City of Albuquerque

**Re: Cedar Street Townhomes Grading and Drainage Plan
Engineer's Stamp dated 8-14-02, (K15/D75)**

Re: Cedar Street Townhomes Grading and Drainage Plan
Engineer's Stamp dated 6-28-02, (K15/D75)

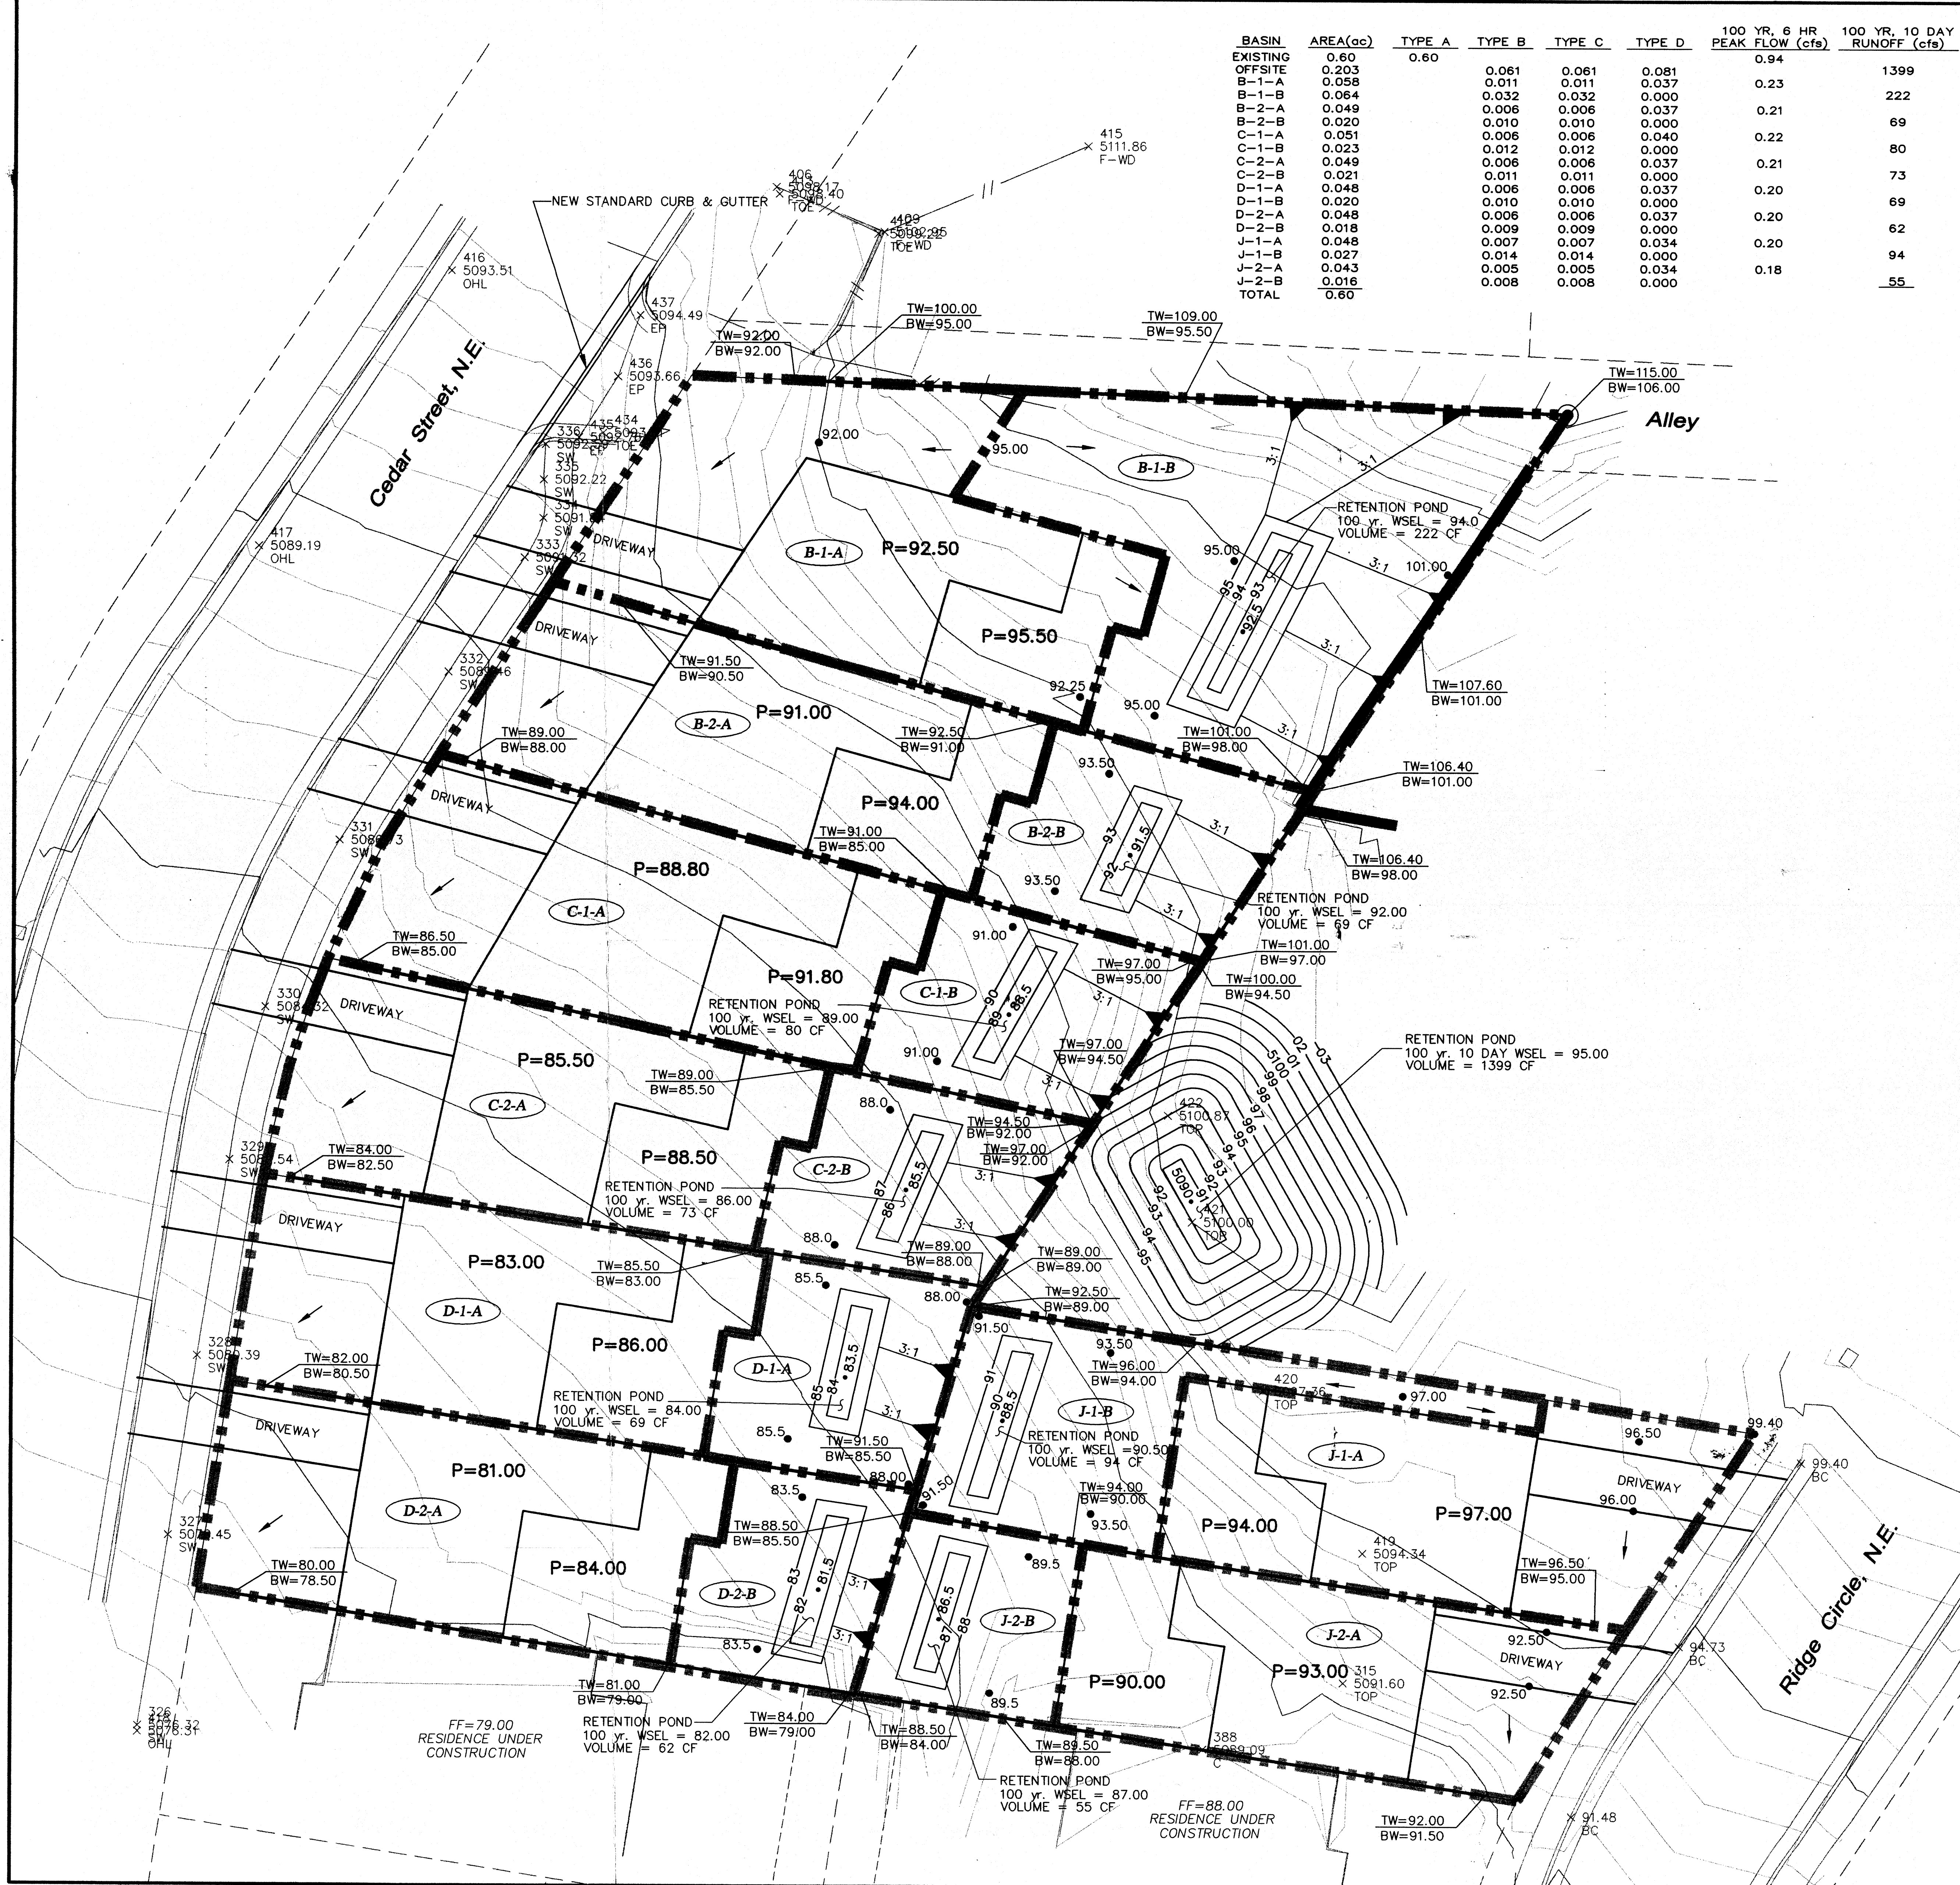
- What size is the storm drain that picks up runoff from lot K? Where is the inlet? Who maintains these facilities? Please show on the plan where the pipe will be located.
- Per City policy, no "developed" (rooftop) runoff is allowed to drain to a backyard pond. Please revise your basins accordingly.
- What are the finished grades of the residences under construction on the south side of your project?
- The vicinity map highlights the wrong properties.
- Is the owner vacating the alley? If so, the drive pad may have to be closed.
